Re: Changes from Application Reference 23/0612/HSE

This application differs from the approved application 23/0612/HSE as follows:

Proposed Ground Floor

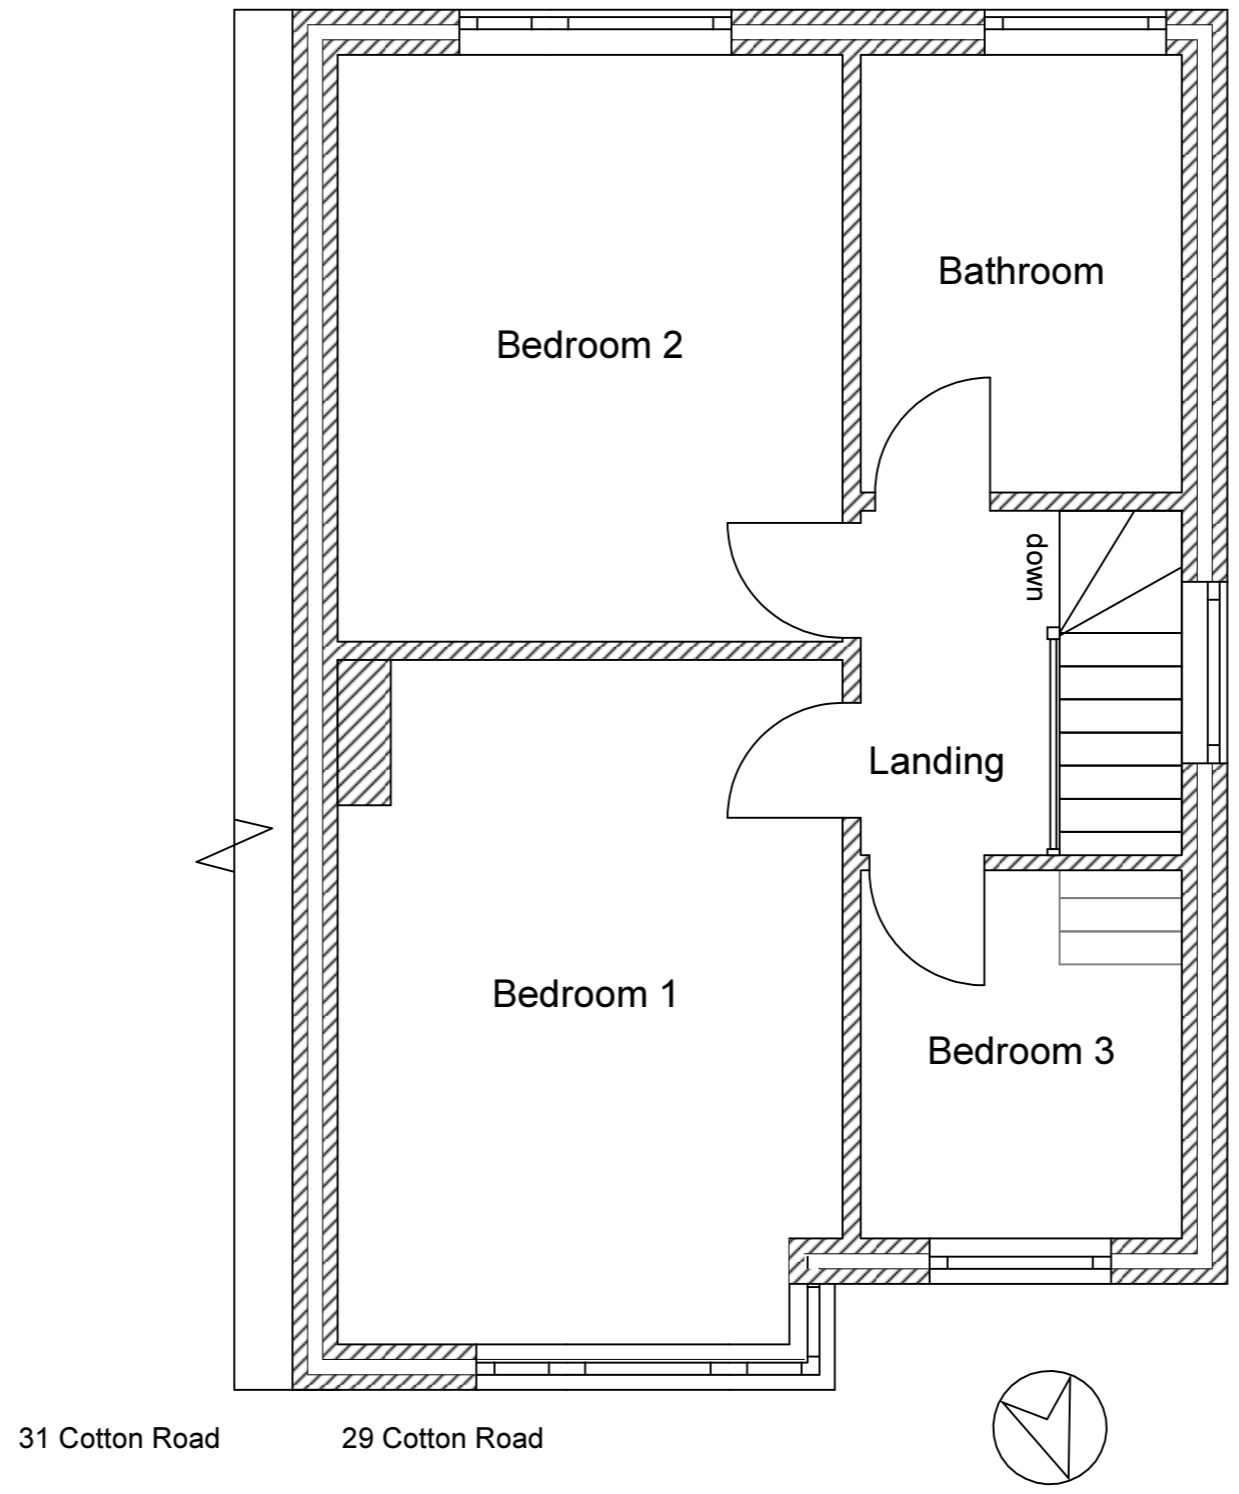
1. The depth of the extension adjacent to 31 Cotton Road has been increased. This increase in depth follows from a prior approval for a larger home extension application which proposed a 4.5m deep extension adjacent to the boundary of number 31 Cotton Road. The approval of that prior approval application is a material consideration that should be taken into account in the determination of this planning application as the impact of the proposed extension on the neighbouring property is the same as the extension allowed by the prior approval application.
2. The rear part of the extension is proposed to have a pitched roof rather than the previously approved flat roof.
